10 July 2025

RE: SUBMISSION LETTER TO STATE SIGNIFICANT DEVELOPMENT APPLICATION | 93 BRIDGE ROAD, WESTMEAD

This submission letter has been prepared by Paro Consulting on behalf of the Community Association DP 220360, Monarco Estate, (the association representing individual Strata Plans SP70764, SP73889, SP74611 and SP77983). The submission letter is in relation to a State Significant Development Application (SSD) application submitted to the Department of Planning, Housing and Infrastructure (Major projects ref. SSD 80904224) for a large-scale residential development comprising 549 dwellings, across two residential towers, basement carparking, landscaping and public domain works.

Figure 6 Section Plan

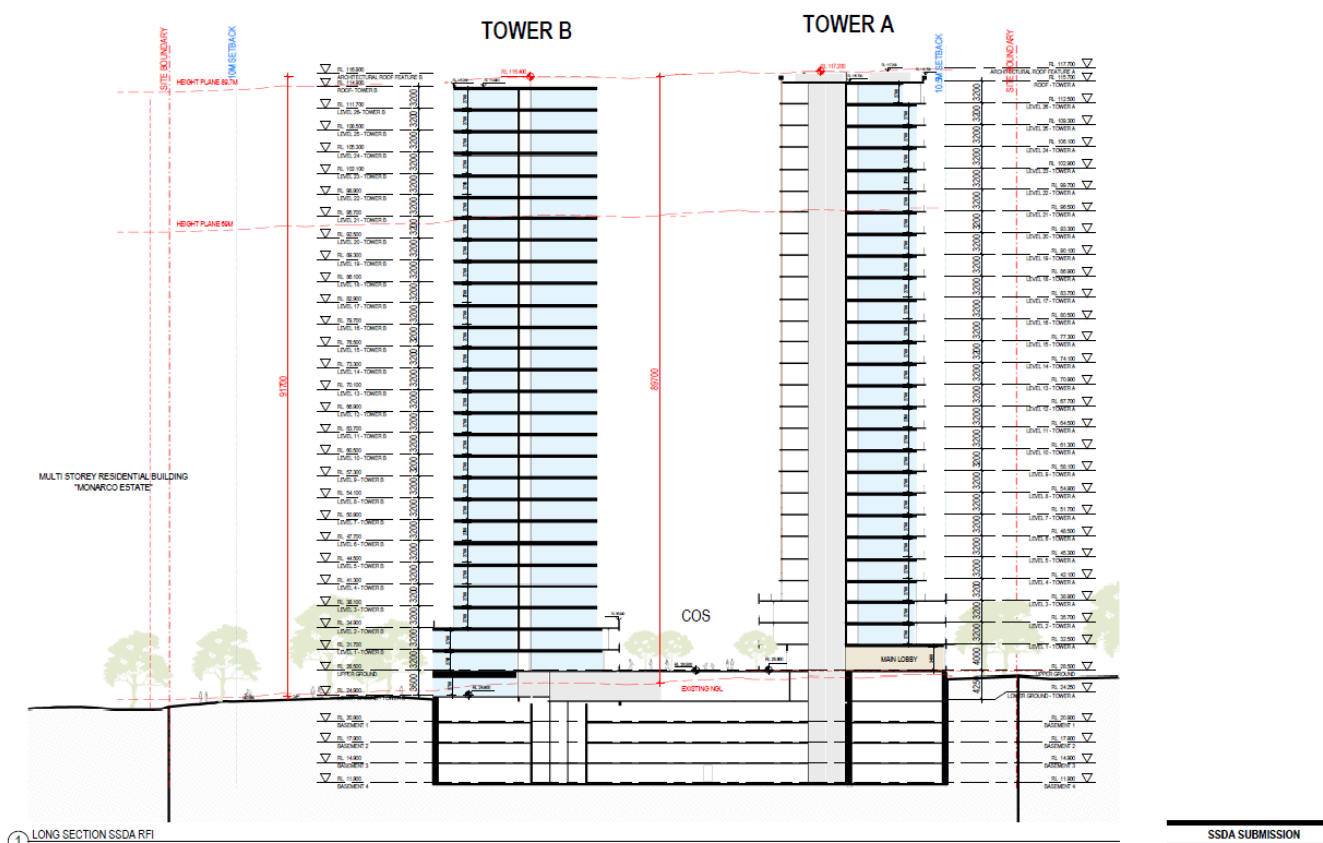
The proposal includes two residential towers presenting a 27-storey (maximum) development with a maximum building height of 89.7m as shown below in Figure 4. The proposed maximum building height is excessive in nature when considered against the current planning controls and the surrounding built context and is considered to present a development that is highly inconsistent with the character of the area. As shown in the figures below, the site is located at the centre of an established residential neighbourhood which exhibits a generally residential character and is predominantly defined by; low scale residential flat buildings of 3 – 4 storeys, Government owned key worker housing consisting of 2 – 4 storey building blocks and multi storey apartment building up to a height of 15 storeys (Figure 5). Further, we note that the Parramatta LEP 2023 Height of Buildings Map depicts a maximum building height of 20m to the subject site, with the permissible building height increasing to 30 - 40m surrounding the Westmead Station to the east and 30 - 62m surrounding the Wentworthville Station to the west (Figure 6). Generally, the preferred building height immediately surrounding the development site ranges from 9m to a maximum of 20m.

Considering the context of the site, two residential towers of approximately 89.7m is highly inconsistent with the character of the residential neighbourhood. The proposed height is disproportionate in relation to its surroundings; it undermines the established character of the locality and raises significant impact on existing residential development.

In our opinion, the proposed building height is not suitable at this site and should not be supported. We submit that the number of dwellings should be reduced to present a more appropriate building height

Figure 10 Solar access to Monarco Estate
 Group: GSA

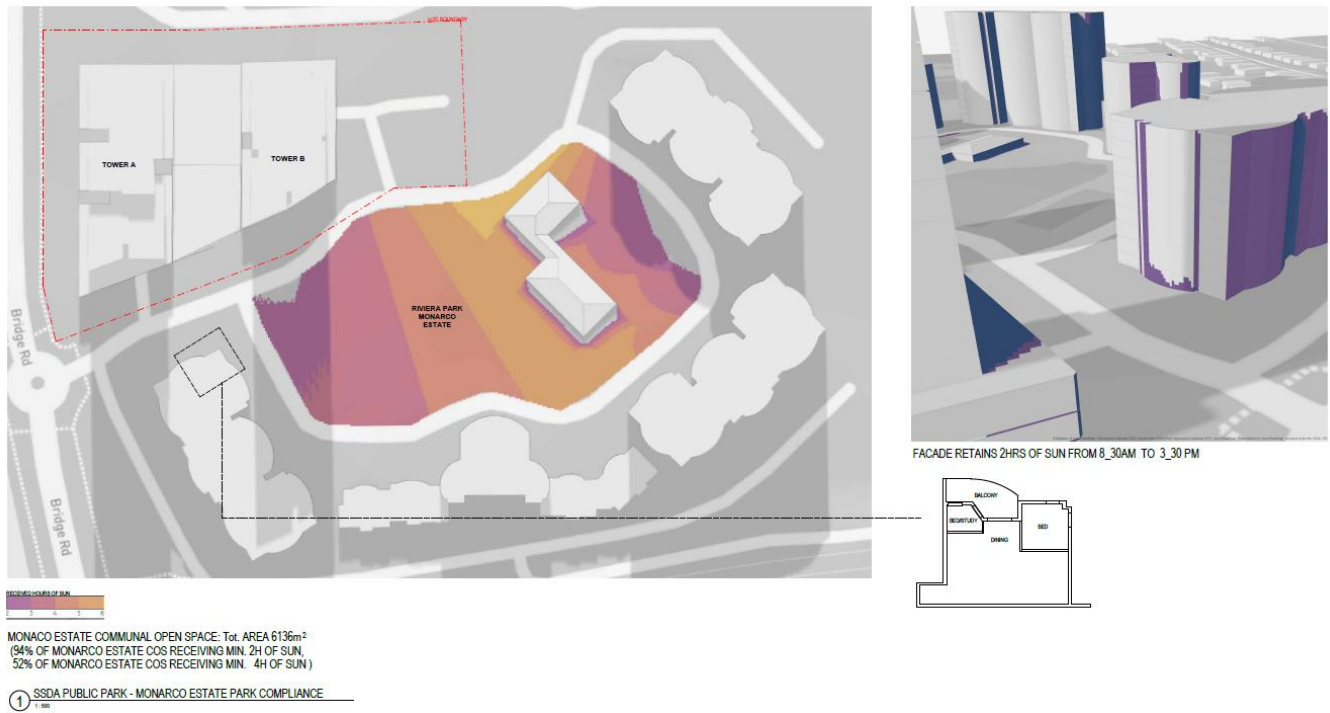
Given the proposal relates to such a significant developmental located directly north of 91 Bridge Road it unlikely that the proposal would have 'no additional impact'. To investigate further, the Community Association (DP 220360) commissioned CAD DRAFT Pty Ltd to prepare an independent shadow analysis of the impact on the residential buildings at 91 Bridge Road. In particular, a high level of concern relates to Block D (SP77987) which is the most shadow-affected residential building of Monarco Estate.

The independent shadow analysis demonstrates that the proposal would generate significant overshadowing impacts to Block D and the principal open space area of Monarco Estate, with access to natural light reduced to below ADG requirements. We submit that the proposal presents a non-compliant overshadowing situation on Monarco Estate and that increased setbacks and / or reduced building height is essential to ensure the amenity of the residents of Block D of Monarco Estate is maintained. We recommend that an updated shadow analysis be prepared and certified by a registered surveyor to ensure accurate building and shadow detail is provided.
